12/10/2020

**Fairfield Sustainable Resource Centre Expansion (SSD-8184)  
Response to Submissions**

## Attachment 1

PROPOSED CARPARK
SUSTAINABLE RESOURCE CENTRE, WETHERILL PARK
CIVIL ENGINEERING PLANS

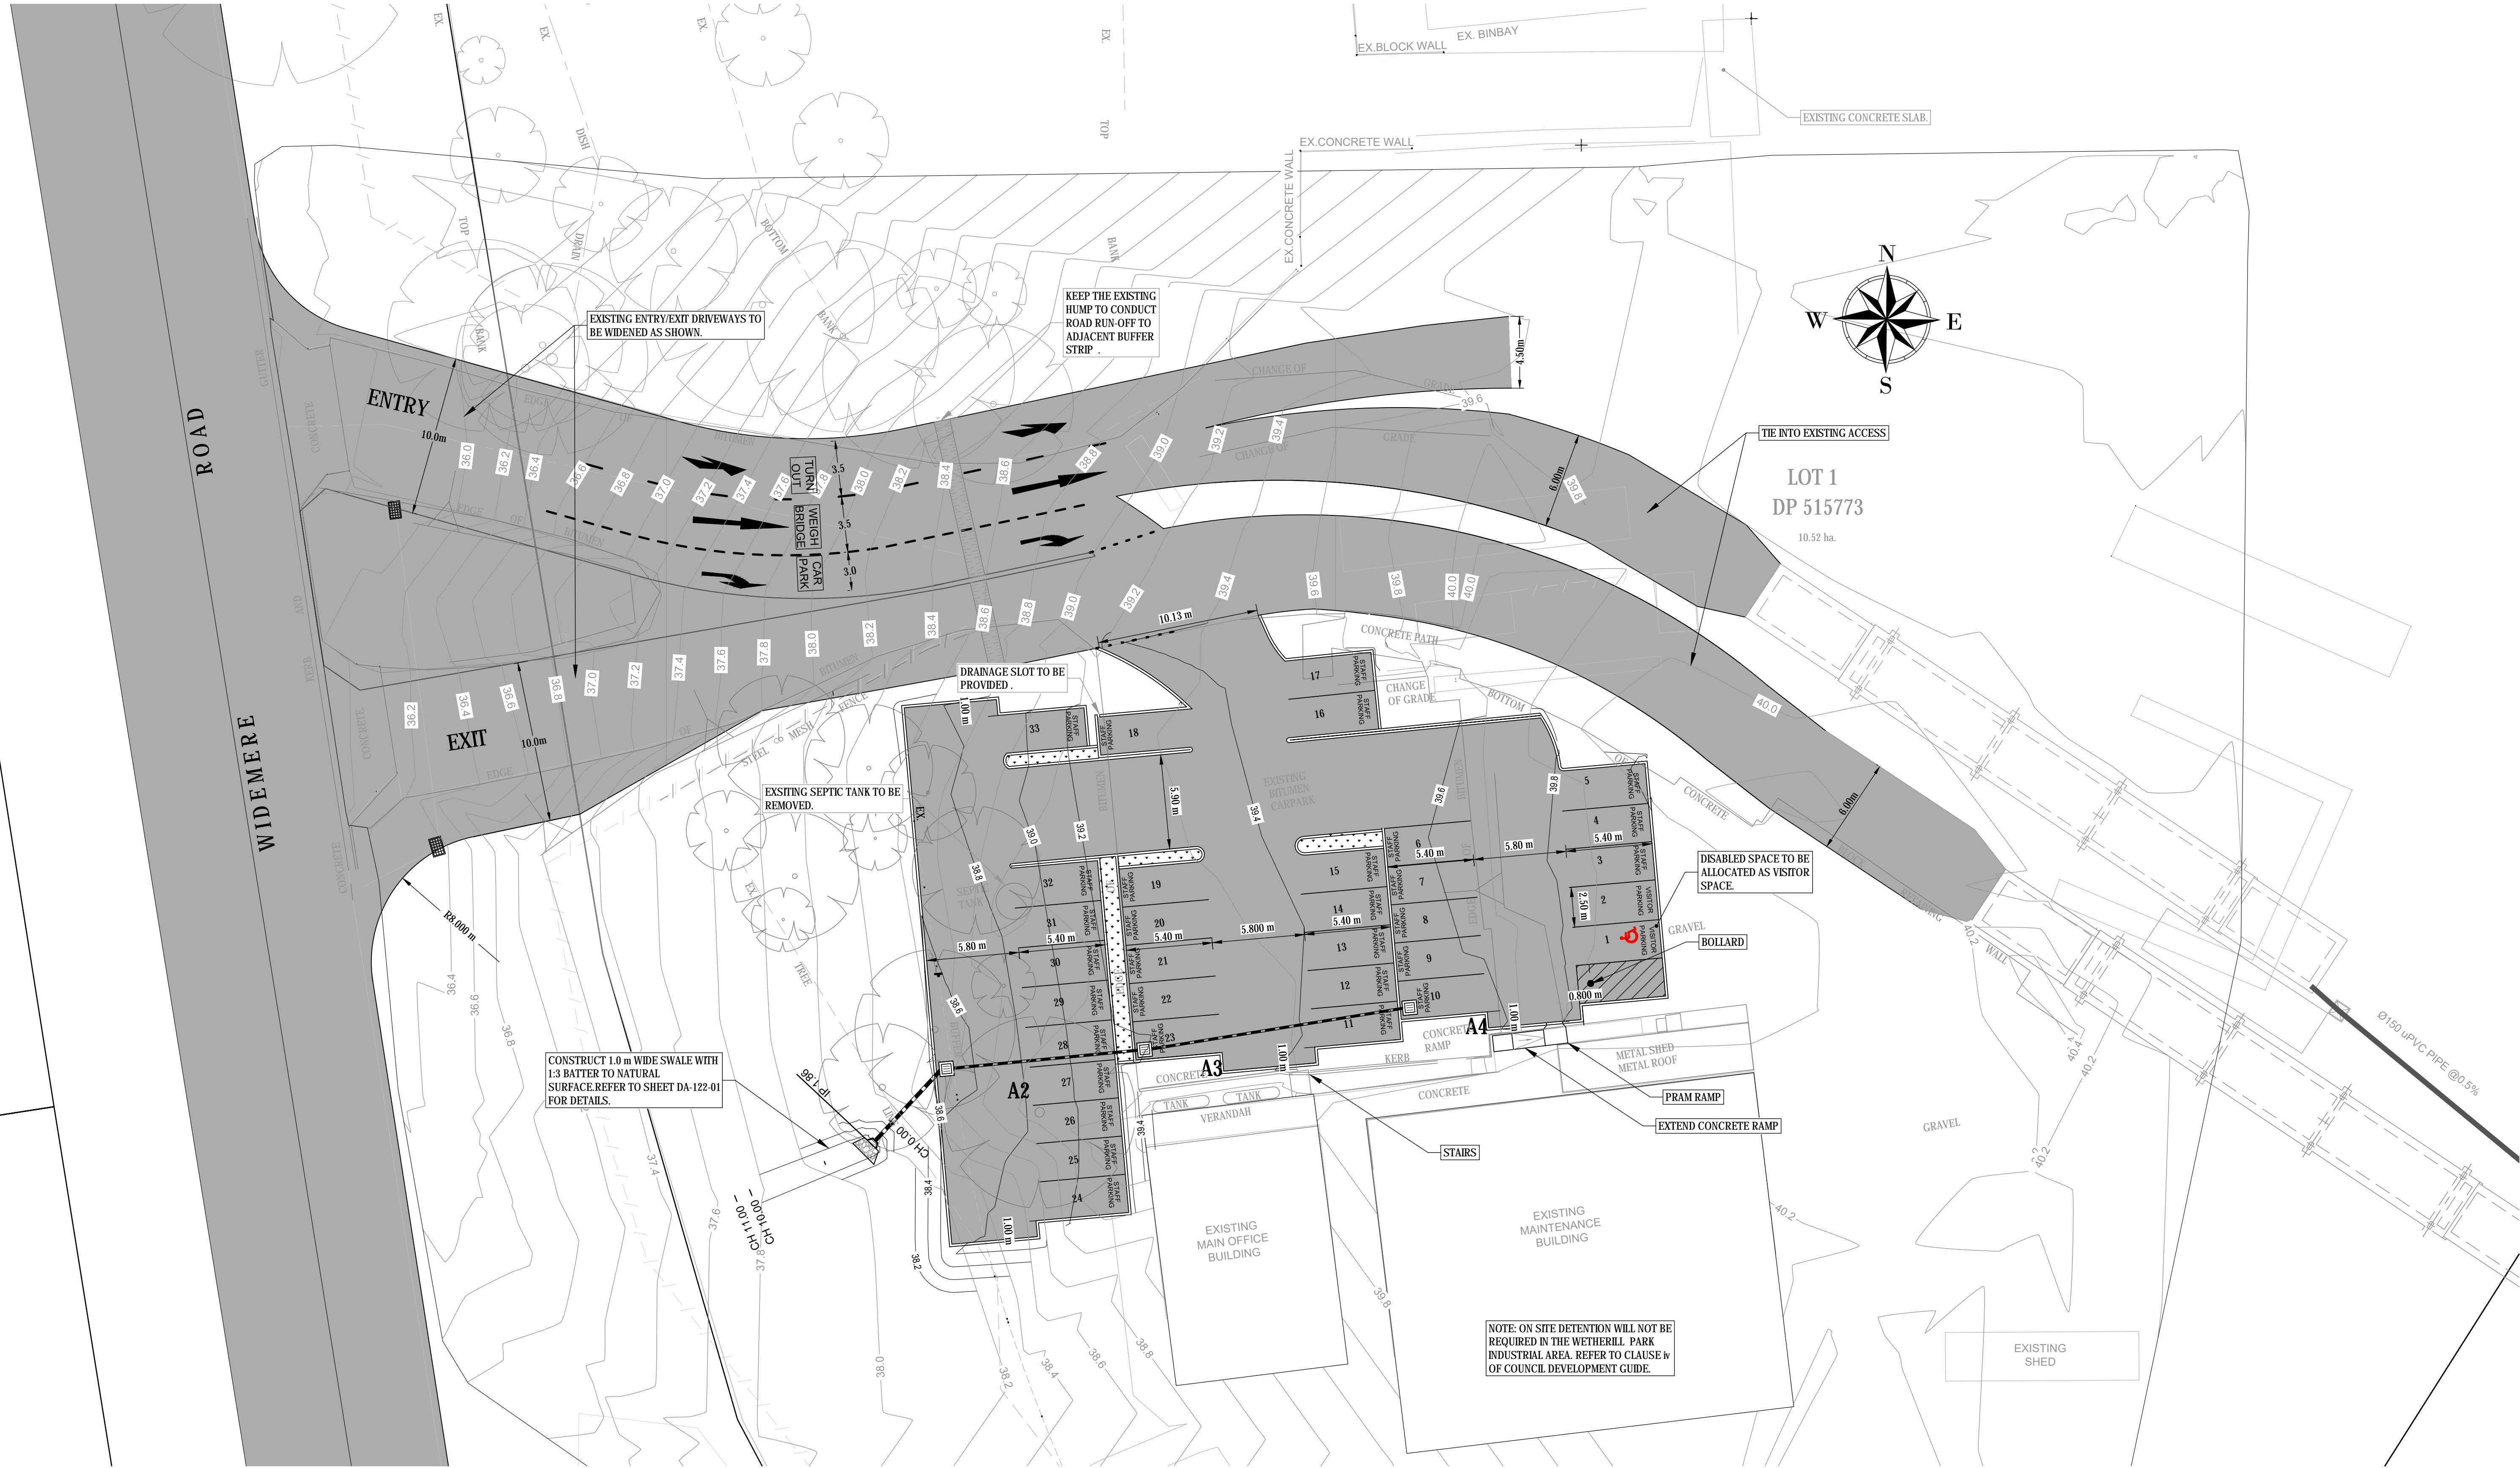
- Provide details on the removal of the septic tank as shown on the civil works plan for the car park expansion.
